RE: FW: Refuse Storage and Collection Strategy Enquiry for the site at 5 Steele House, Harwich CO12 3PN.

The proposal is for a construction of new 1 bedroom/2 persons flat to the top of the existing building, site at 5 Steele House, Harwich CO12 3PN.

Drawing Title:  
PROPOSED SITE, LOCATION AND BLOCK PLANS

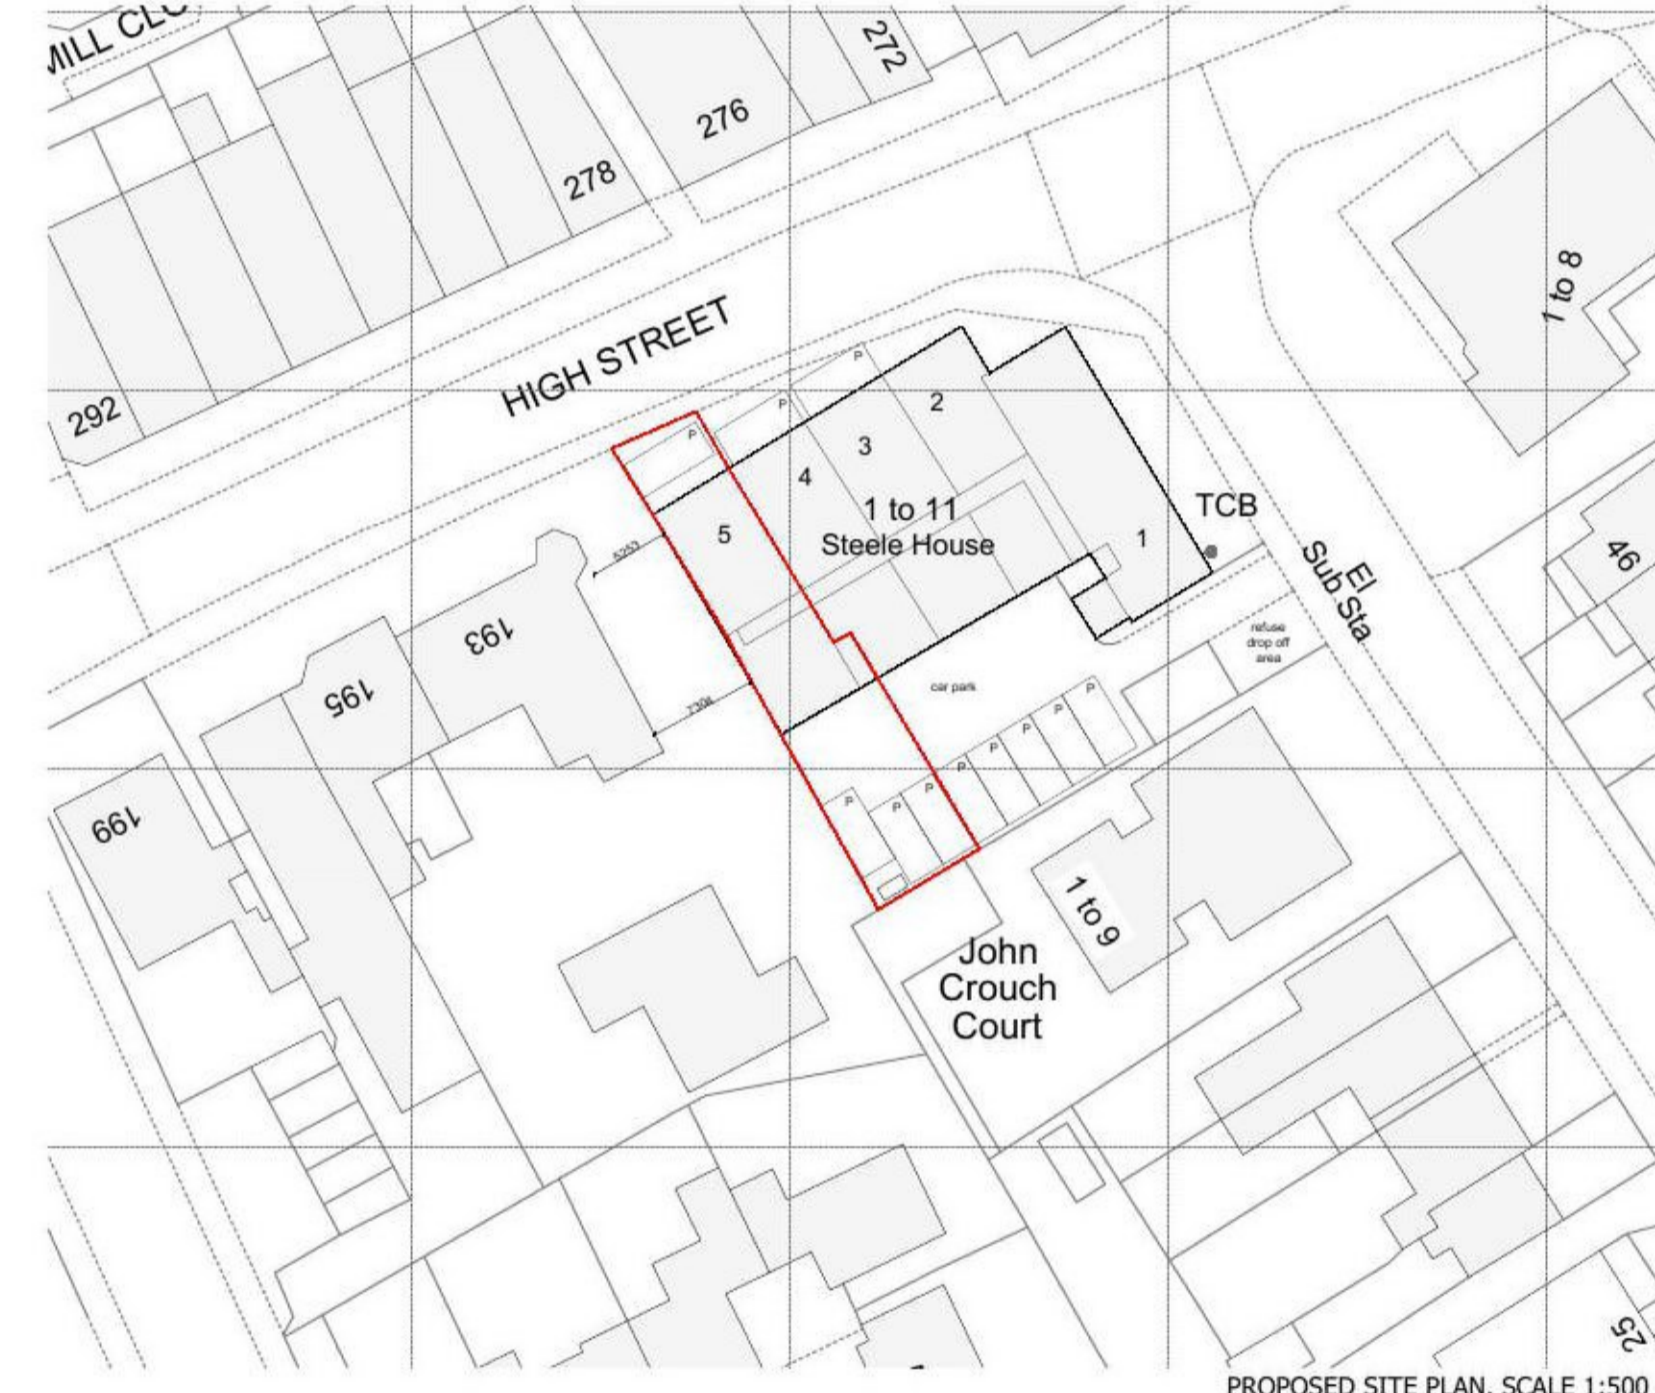
All correspondence I have had with the Agent has been in respect of this area. To my knowledge there is not a bin storage area in the location identified on the plan, however it may be that I have not been made aware of one.

Elaine confirms that currently refuse is placed on the piece of land circled in the attached screenshot where they are then collected by our contractors and NOT in the communal bin storage area as referred to in your waste strategy.

With the collection vehicle unable to access the parking area of Steele House the walking distance from the collection vehicle to the communal bin storage area would be greater than 25 metres.

I can confirm that the refuse collection point for Steele House is indeed the small patch of land to the left of the entrance to the car park, with both refuse and recycling being collected from this point. Refuse is to be presented in sealed refuse sacks with recycling presented in plastic boxes supplied by Tendring District Council.

Could we therefore also suggest for the future residents of the proposed flat 5D to bring their refuse in sealed bags and boxes to the area by the entrance to the car park, on a collection day, it would be collected from there by the Council Collections Team ?
